Item No. **Report of the Head of Development Management and Building Control**

Address: 14 WILLOW TREE LANE HAYES

Development: Change of use from Class C3 dwelling house to 7-bedroom / maximum 8 person HMO Use Class Sui Generis

LBH Ref Nos: 5516/APP/2025/2441

Proposed Floor Plans

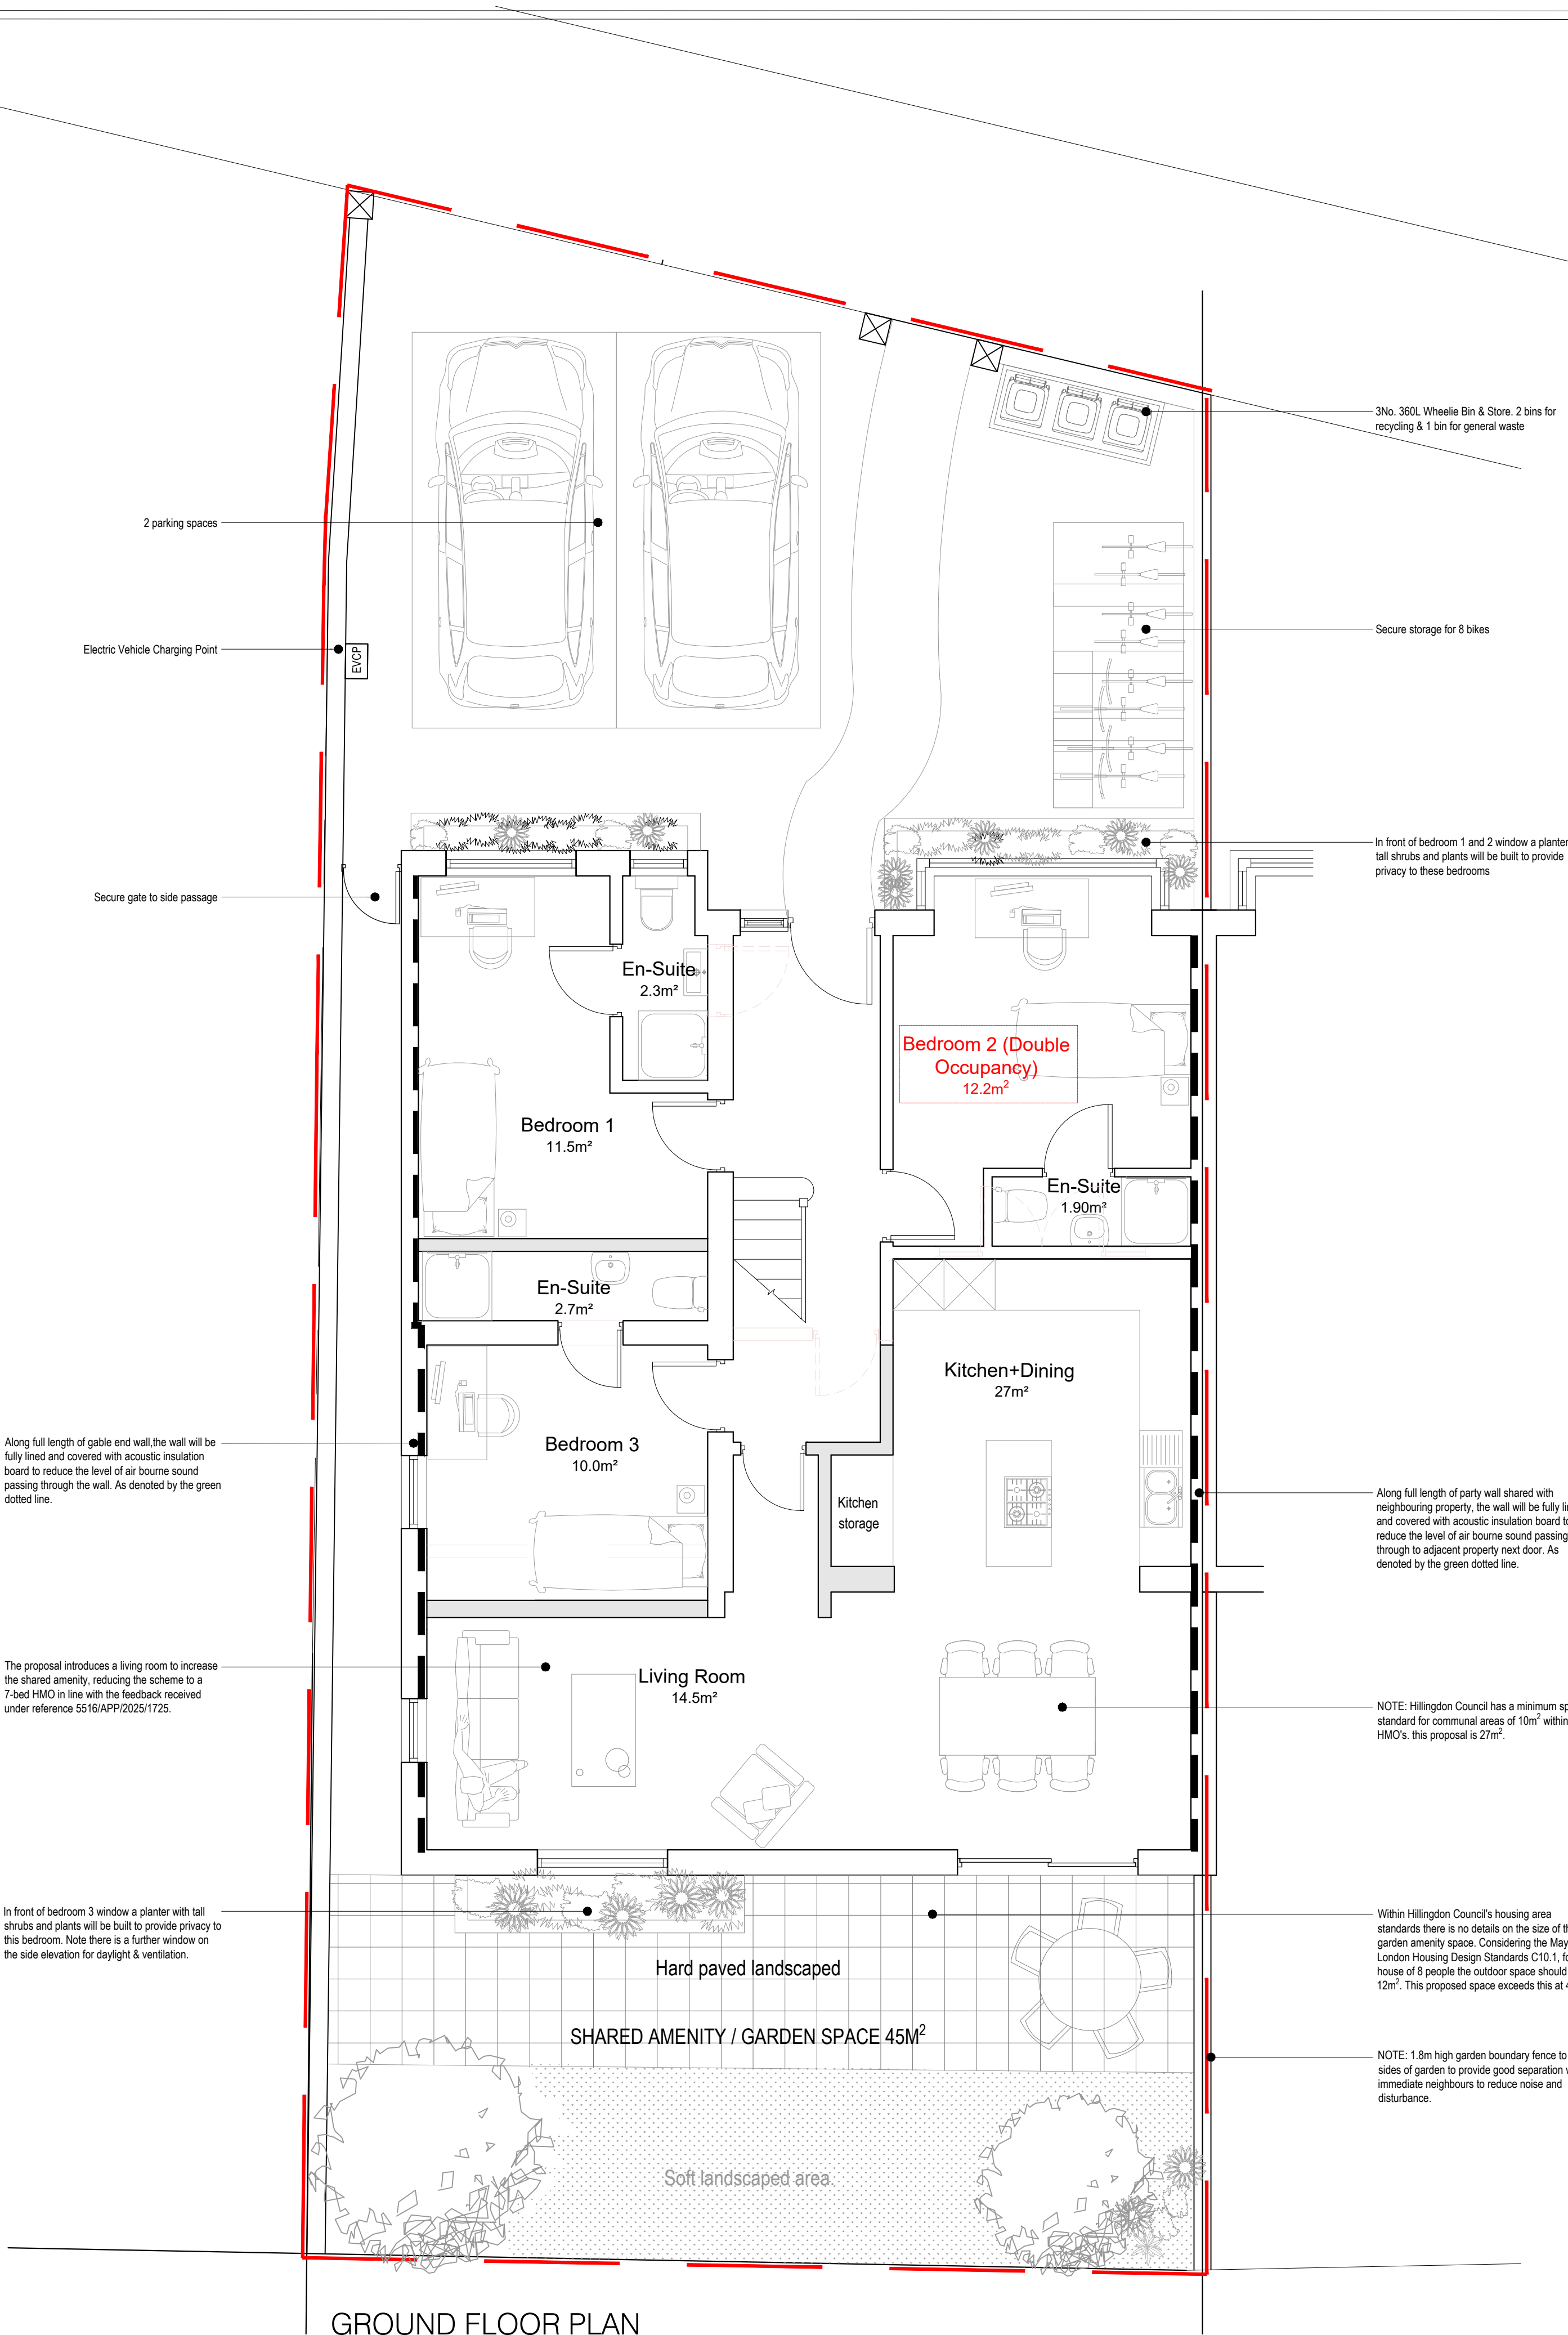
Whilst the HA accepts the provisions outlined in the TS, the proposed forecourt layout remains extremely constrained. It attempts to accommodate two car parking spaces, sheltered bicycle storage for eight cycles, and refuse bins within a limited area. Swept path analysis indicates minimal tolerance for vehicle movements, particularly when entering the forecourt, which will require reversing and could involve multiple manoeuvres. This poses a risk of obstructing traffic along Willow Tree Lane, especially buses near a busy junction.

Current guidance requires a minimum of 6 metres of clear space in front of parking bays; however, the proposed layout does not provide sufficient clearance for vehicles to enter in forward gear. Consequently, vehicles may need to reverse repeatedly to access bays, creating potential hazards for pedestrians and causing delays to traffic, particularly buses.

Furthermore, the TS does not include dimensions on the submitted plans to demonstrate compliance with key standards, such as parking bay sizes, 6m clearance, and pedestrian path widths, despite previous HA requests.

Moreover the proposal illustrates that there to be 2 spaces to be provided at the front of the site. These are heavily compromised by the proposed location of the cycle store which in accordance with the London Plan should provide 8 secured and covered cycle spaces. Swept path lines are illustrated on the site plan but clearly there would be a potential conflict between the vehicles entering and existing the site with the cycle store and bin store.

Concerns were previously raised in the consideration of application reference 5516/APP/2025/686 with regards to the privacy of Bedrooms 1 and 2 which are located on the ground floor given the only outlook from the windows would be directly facing the front driveway and would be overlooked

It is however noted that the ground floor window serving 'Bedroom 3' on the ground floor side elevation would face directly onto the boundary treatment at close proximity. The occupiers of this room not be provided with adequate levels of outlook and daylight due to the obscure glazing that would be required for the lifetime of the development. This is considered to warrant a separate reason for refusal.

by other occupiers and visitors to the accommodation. This current proposal seeks to address this concern and the submitted plans indicate a barrier / buffer zone has now been added to the design in front of each bedroom window in the form of a planter filled with planting which would stop a person directly approaching right up to the window. Officers consider this to be a satisfactory solution.
